MP09_0187 – MIX USE BUILDING AT 6-16 ATCHISON STREET, ST LEONARDS

I refer to the Department of Planning's (DoP) letter dated 27 September 2010 (DoP Reference No: MP09_0187) with regard to the abovementioned Development Application (DA), which was referred to the Roads and Traffic Authority (RTA) for comment under Part 3A of the *Environmental Planning and Assessment Act, 1979* and Clause 104 - Column 2 of Schedule 3 of State Environmental Planning Policy (Infrastructure) 2007.

I wish to advise that the Sydney Regional Development Advisory Committee (SRDAC) considered the traffic impact of this application at its meeting on the 20 October 2010. Below are the Committee's recommendations and RTA's comments on the subject application:

B99 ENTERING DRIVEWAY OPTION 1

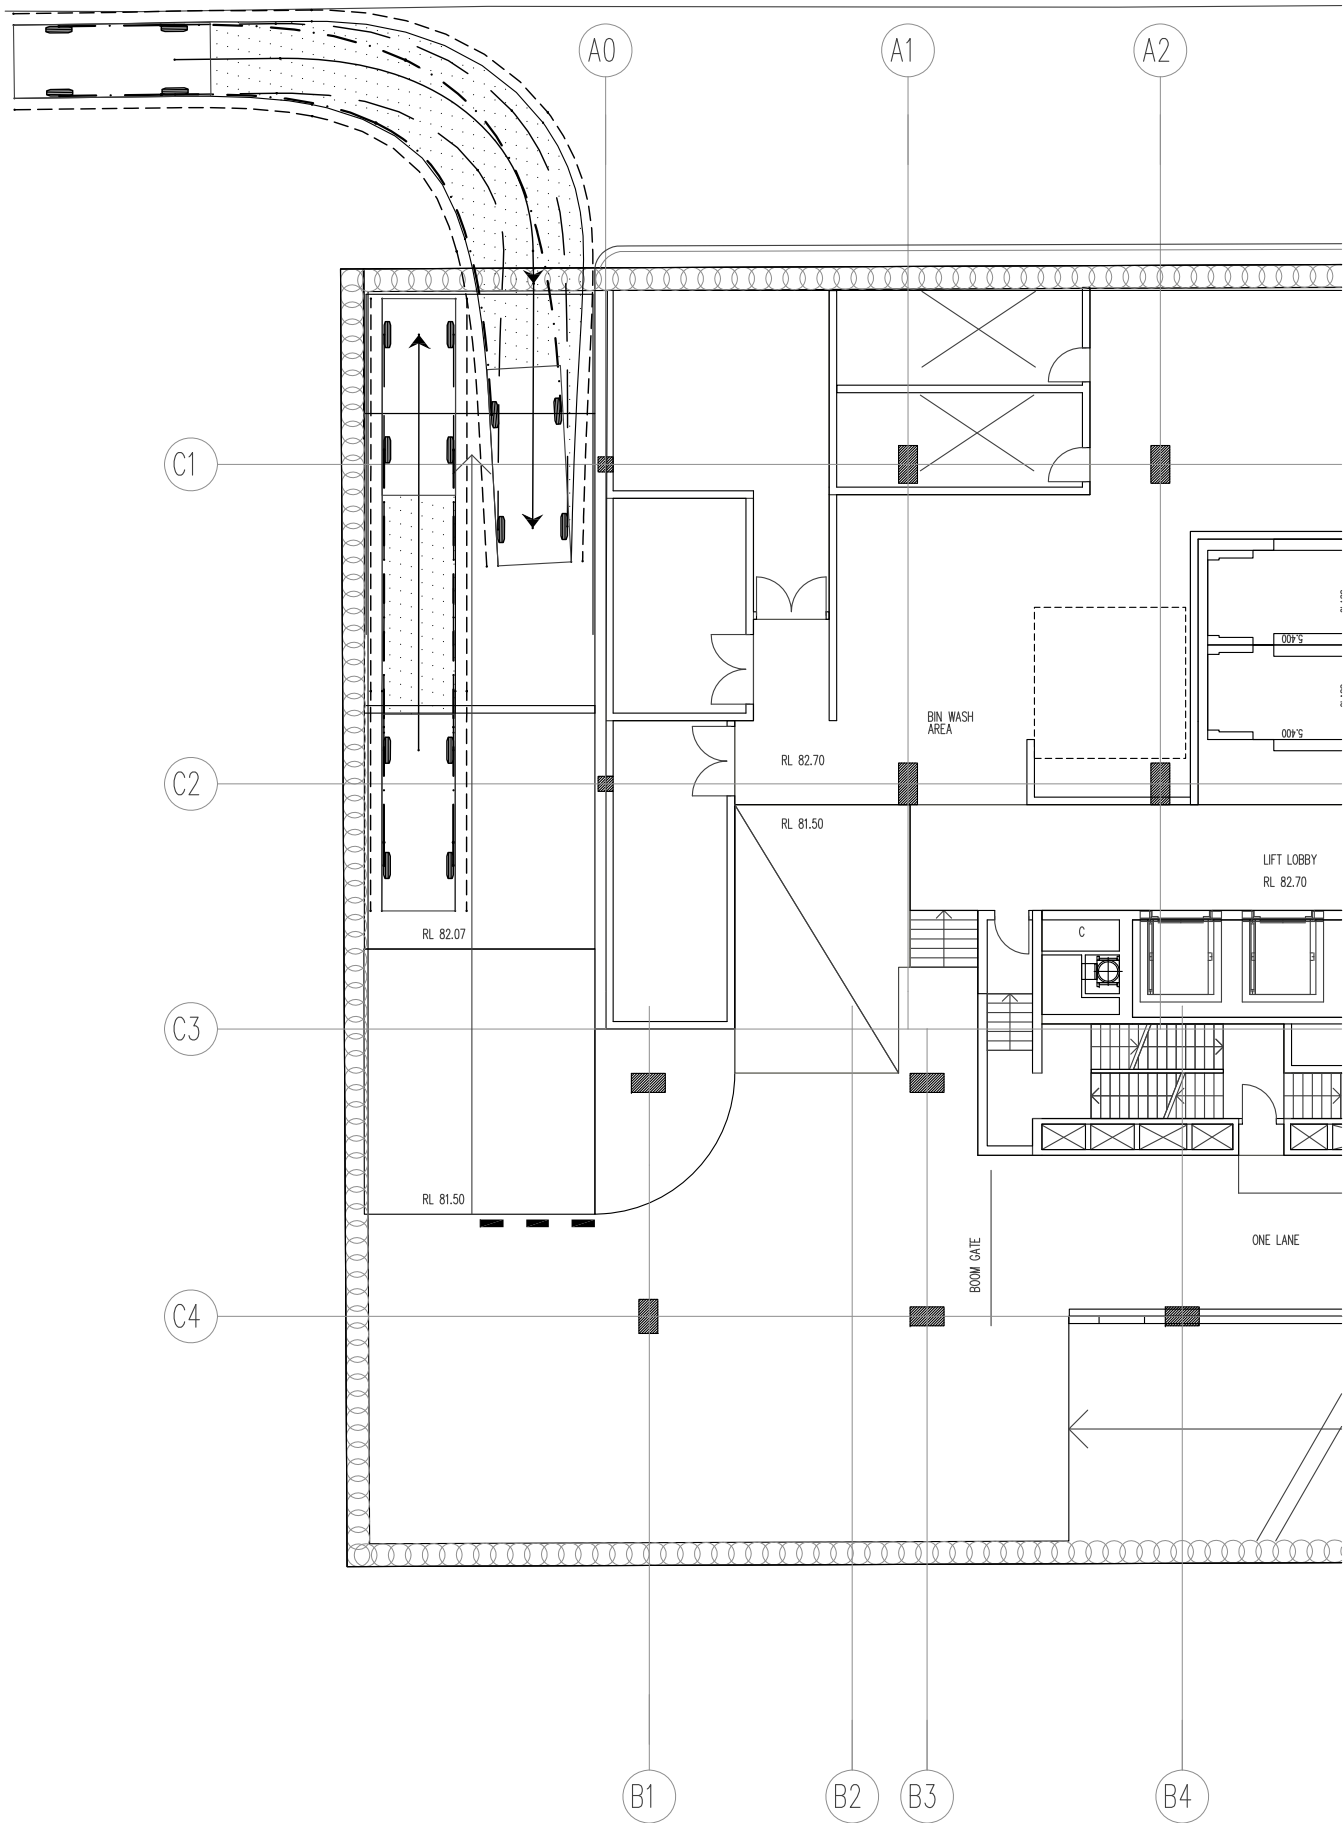
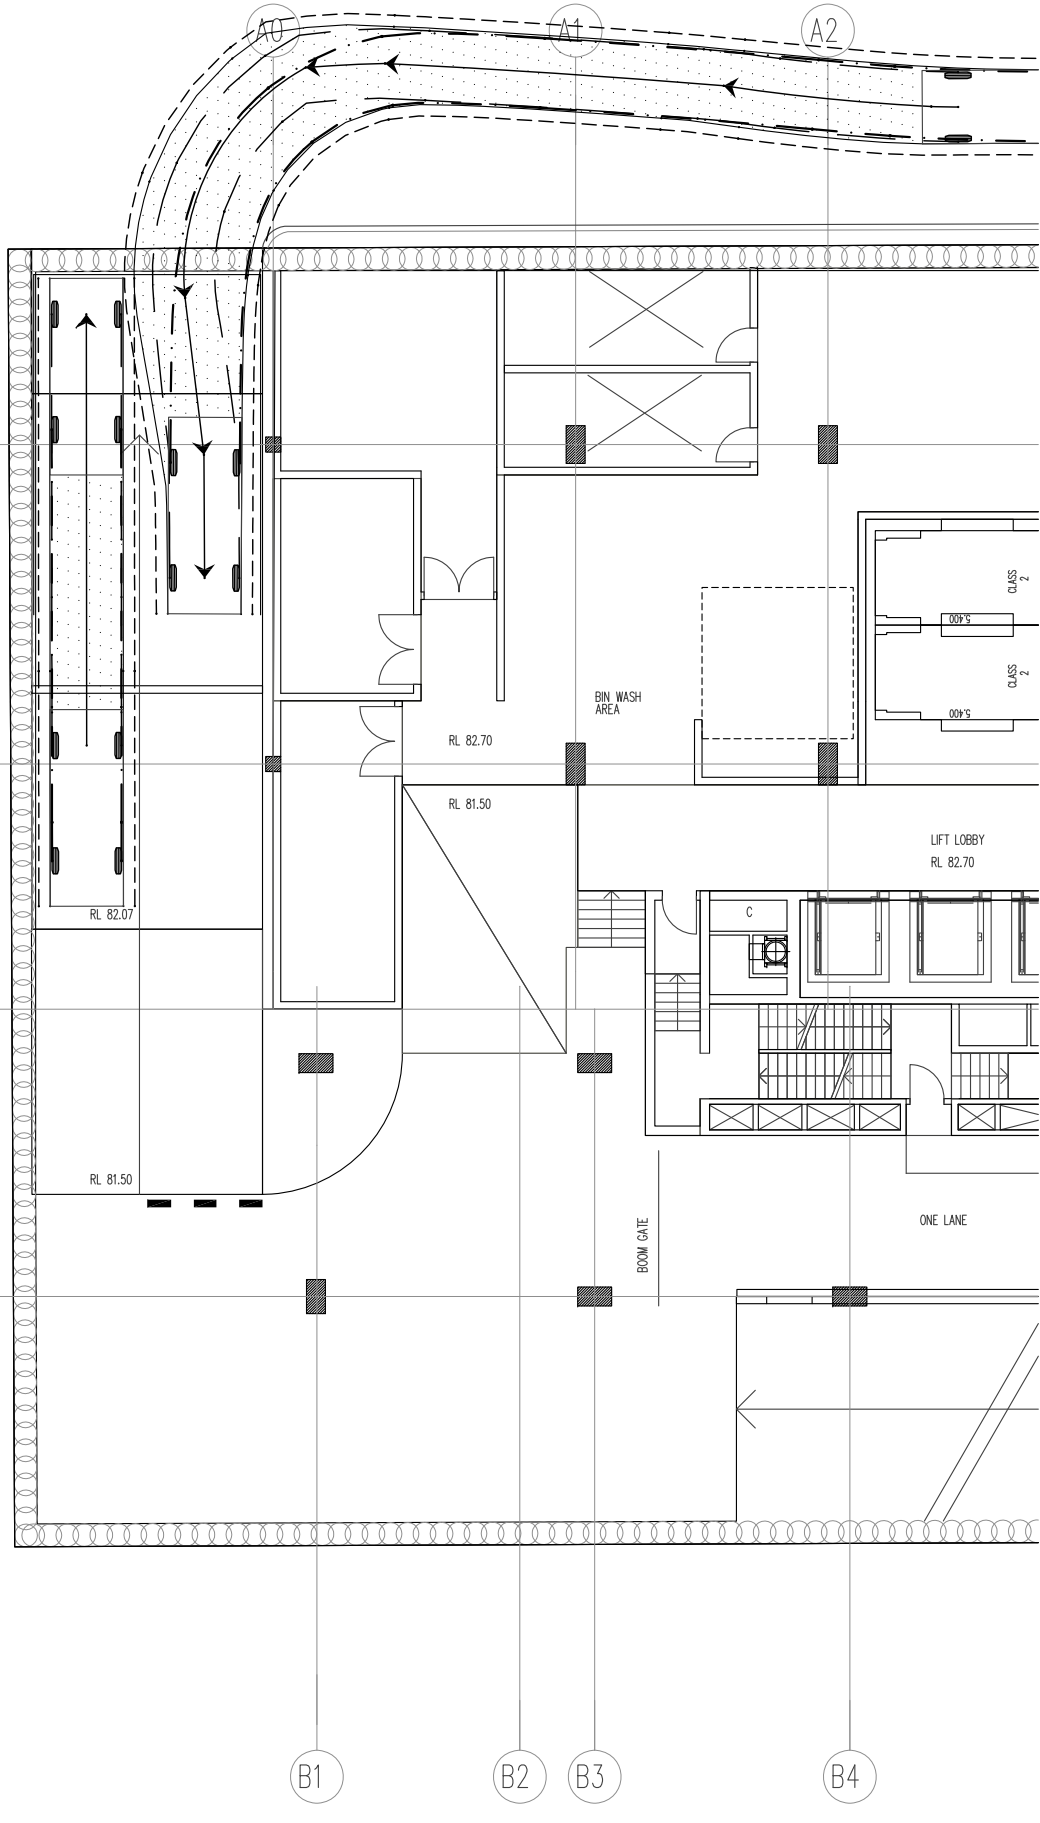
2. Swept path analysis to the satisfaction of DoP and Council shall be provided that the largest vehicle (i.e. 6.4m small rigid vehicle) can physically enter and exit Atchison Lane and the access driveway. Additional splays or modification of the kerb alignment may be required on Atchison Lane, connecting streets and on the access driveway.
3. A condition that prohibits trucks longer than a 6.4m small rigid vehicle from entering the site should be included in the DA consent.
4. The residential component of the proposed development should be designed so that road traffic noise from Pacific Highway is mitigated by durable materials and comply with the requirements of Clause 102 – (Impact of road noise or vibration on non-road development) of State Environmental Planning Policy (Infrastructure) 2007.
